SUBJECT: SFD2208-0051
SINGLE FAMILY DWELLING

Here are the results of all Inspections located at **507 S LINCOLN ST:**

SHEET NAME
1ST_FLOOR
SHEET #

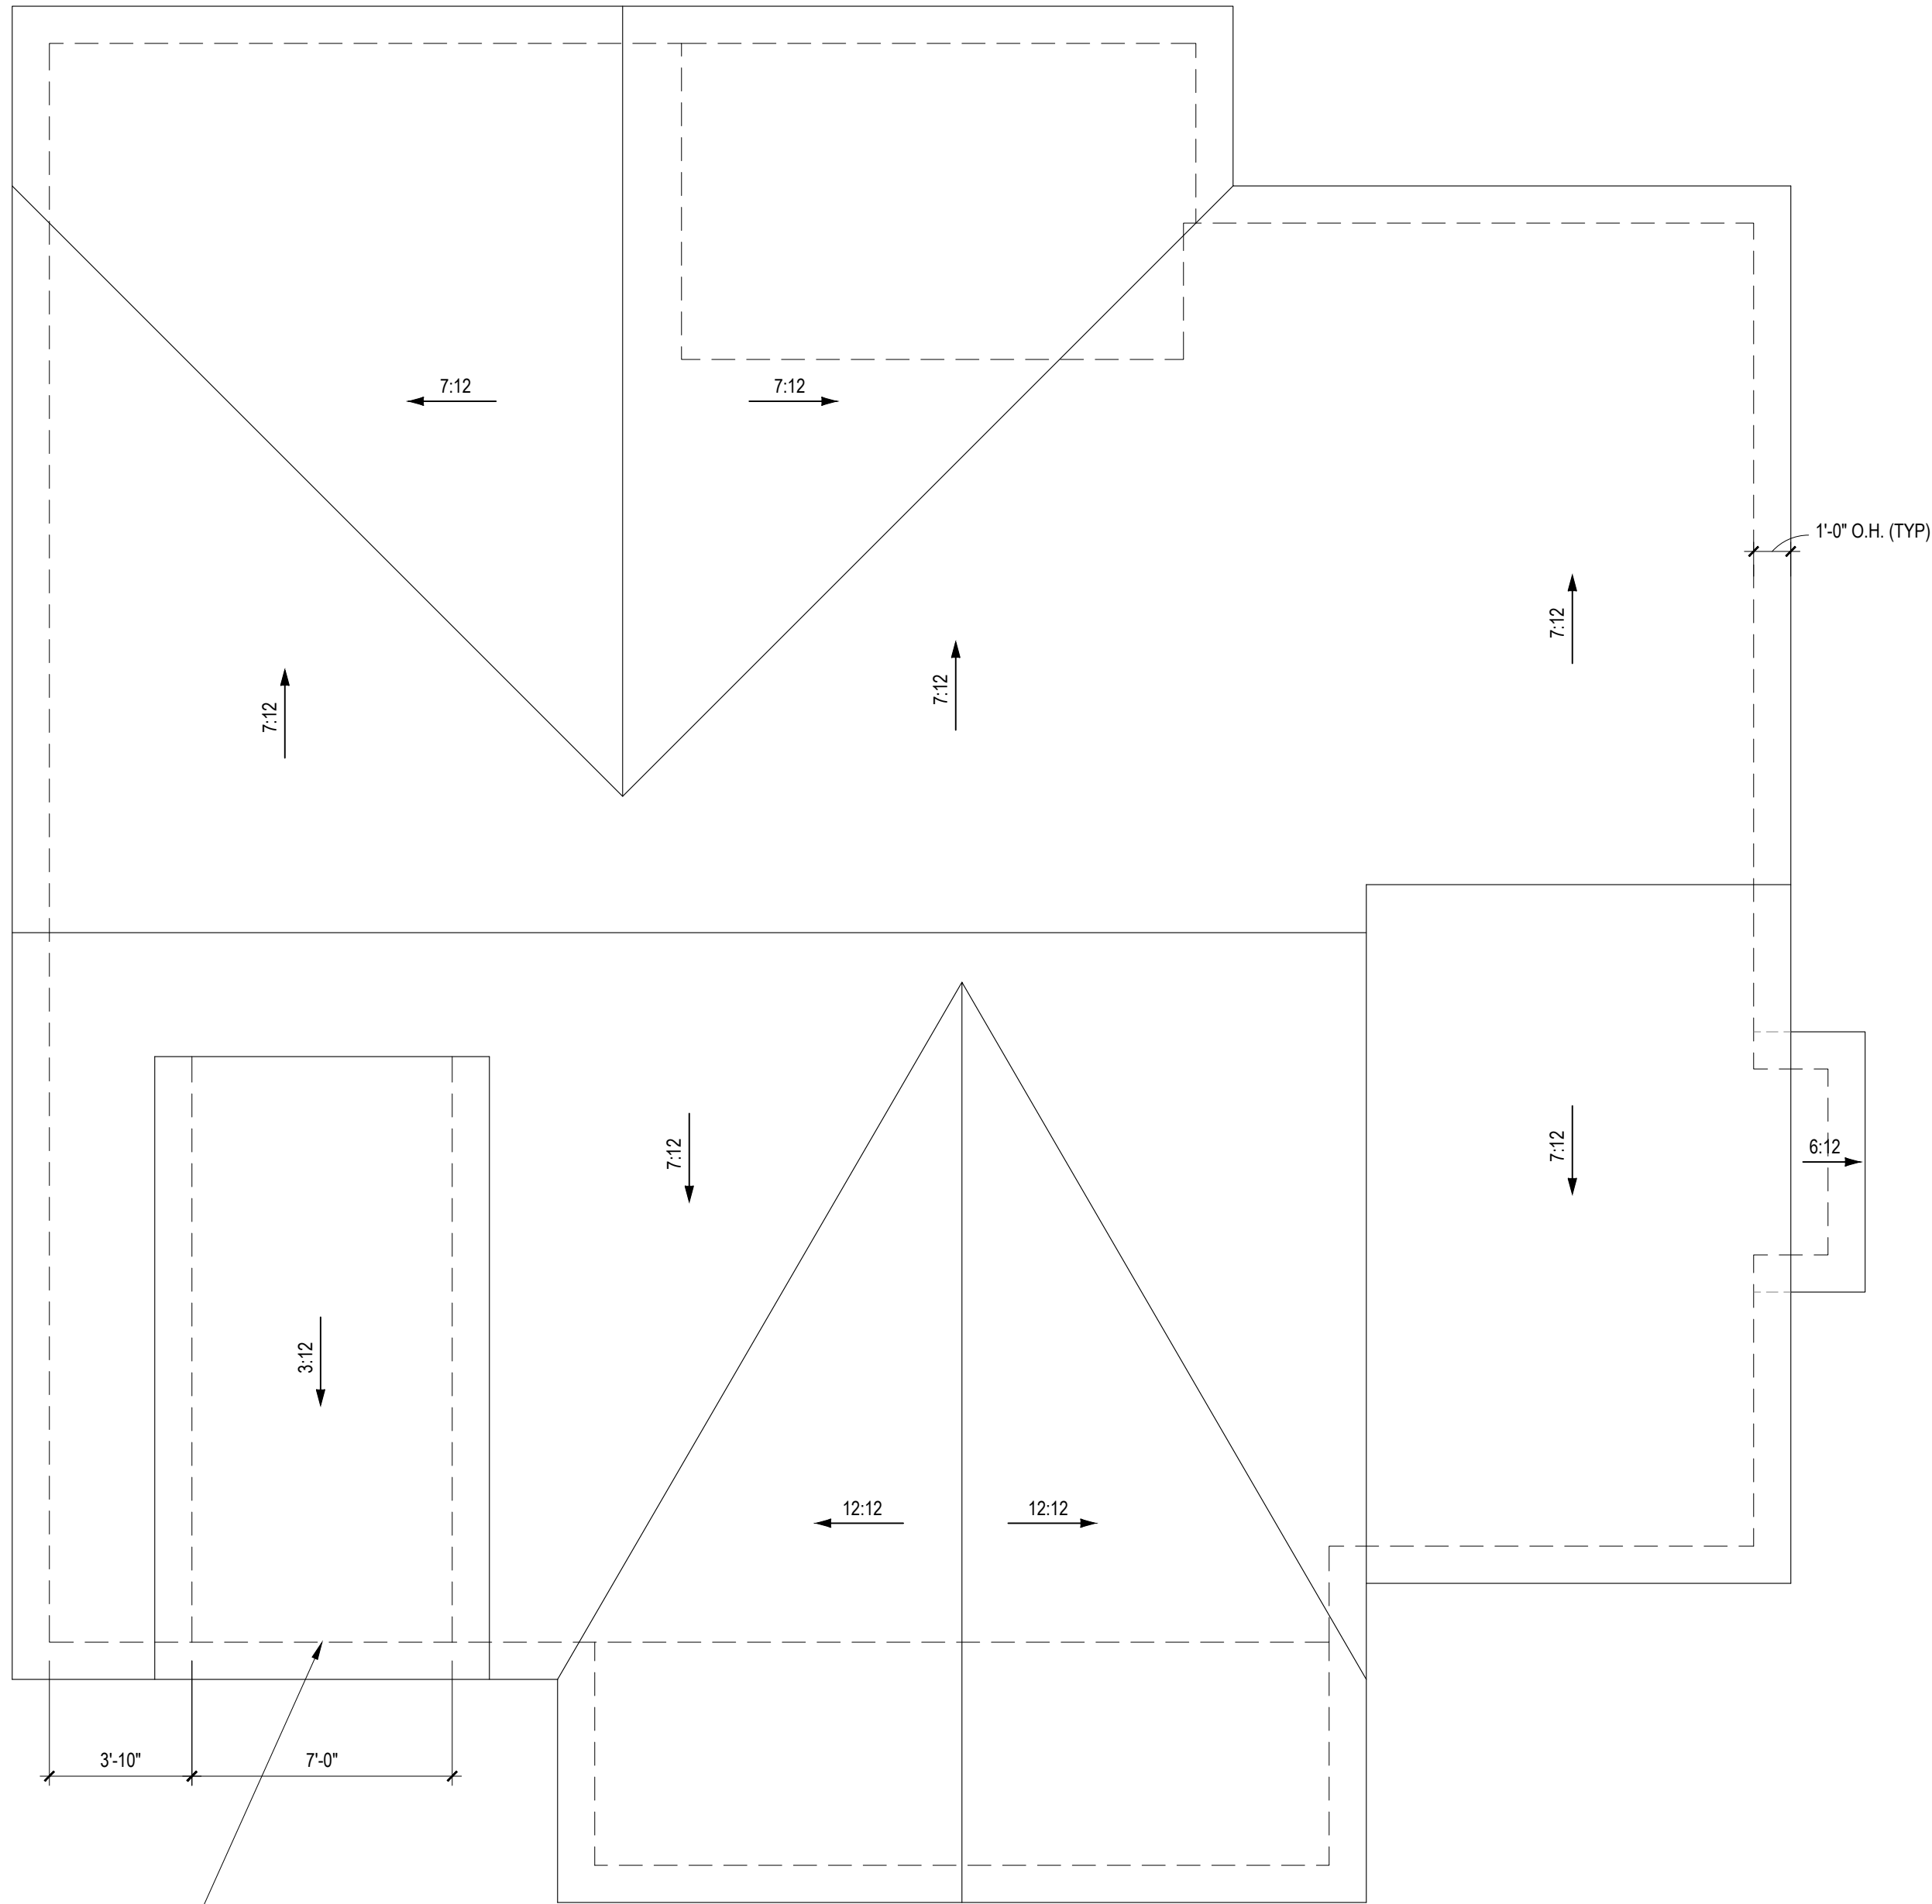
Need 3 feet of water in standpipe for drain test. Window above master bath tub and outside of shower must be tempered. OK to insulate

Inspection Type: INSULATION
Scheduled Date/Time: 11/17/2022
Completed Date/Time: 11/17/2022
Inspector: Deen Taylor
Result: APPROVED
Remarks: eTRAKiT Inspection Request
Notes: 11/16/2022 9:58 AM Pleasant Builders of NC LLC
I have ordered tempered glass replacement for the window over tub. There will NOT be Shower doors for the stand up shower in Master bath. Let me know if that means the window beside shower will pass inspection without being tempered glass. Thank you!
Contact Name: Pleasant Builders of NC LLC
Site Address: 507 S LINCOLN ST
Phone: 9198787685
e-Mail: pleasantbuildersnc@gmail.com
